**CITY OF ALBUQUERQUE  
PLANNING DEPARTMENT  
November 10, 2015  
DRB Comments**

**PROJECT # 1010656**

**APPLICATION # 15-70404**

**RE: Lots 28 - 30, Block 30, North Albuquerque Acres Tract A,  
Unit B**

**LEGAL DESCRIPTION**  
 WILSHIRE ESTATES SUBDIVISION  
 (REPLAT OF LOT 28-31, BLOCK 30, TRACT A, UNIT B)  
 WITHIN NORTH ALBUQUERQUE ACRES  
 CITY OF ALBUQUERQUE  
 BERNALILLO COUNTY, NEW MEXICO

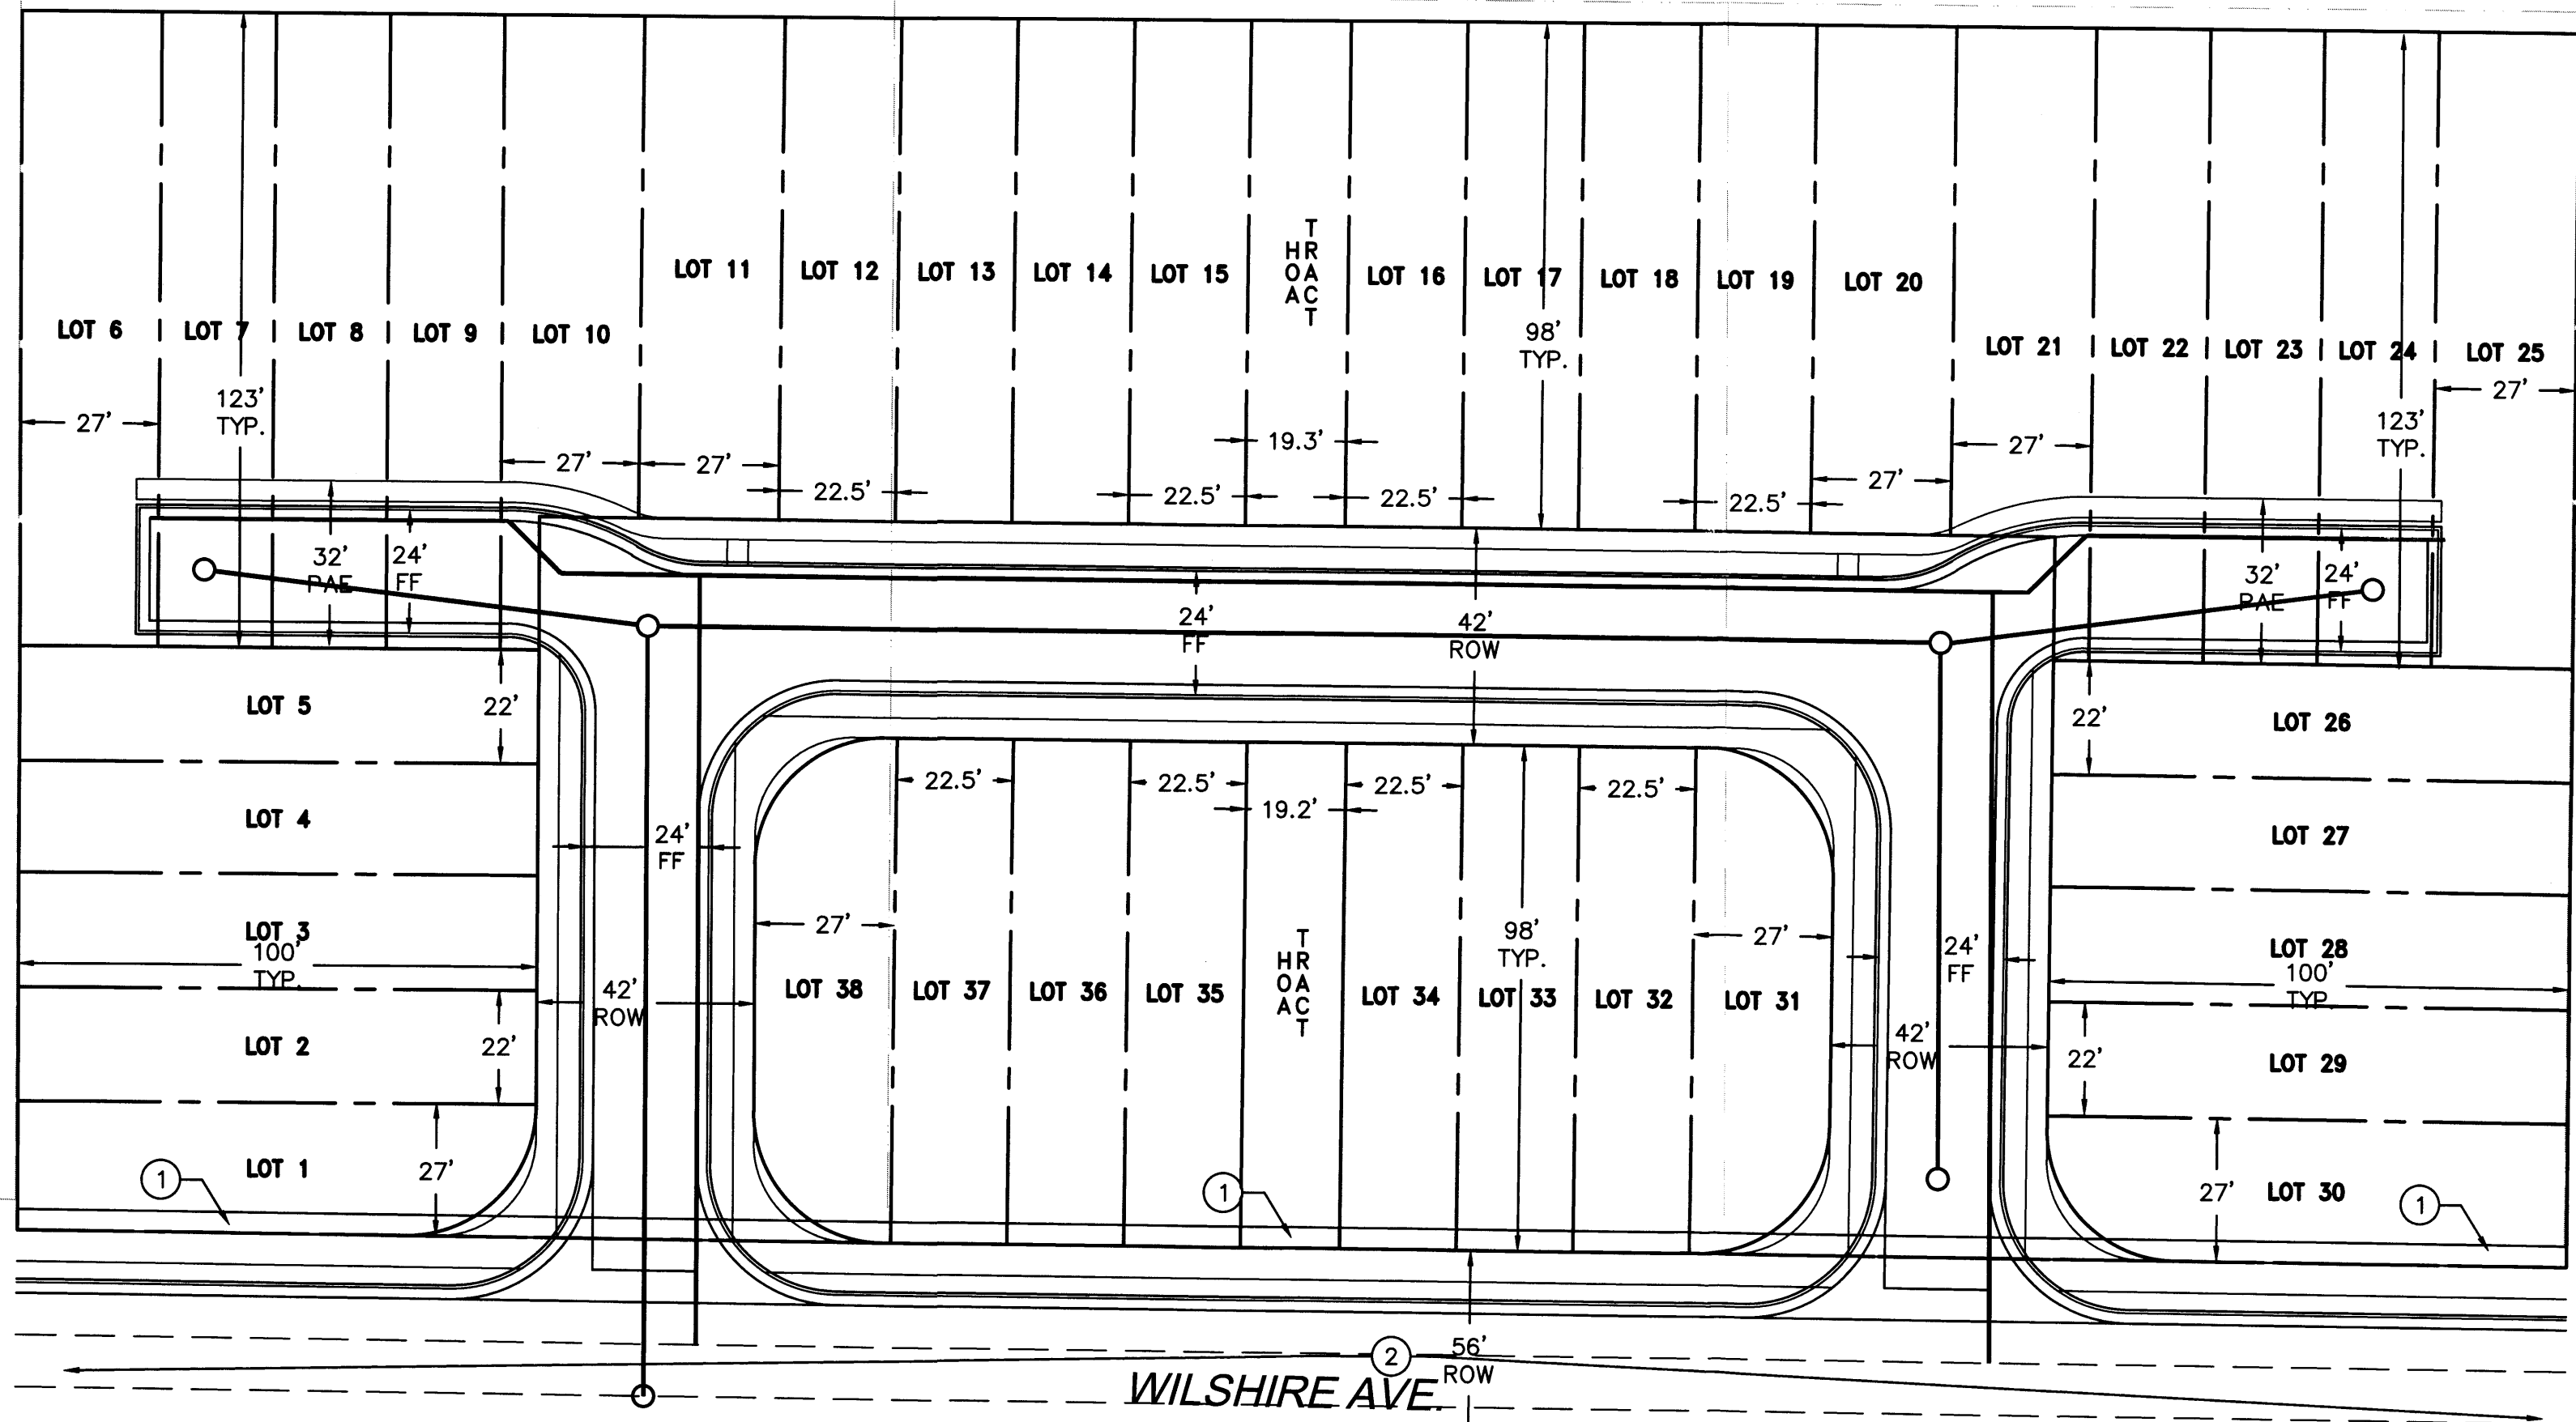
SU-2/ RT is not an existing Land Use District in the North I-25 sector plan; nearby designations are R-D or SU-2/ LMDR.

The maximum number of lots on a stub street is four – both stub streets show 5 lots.
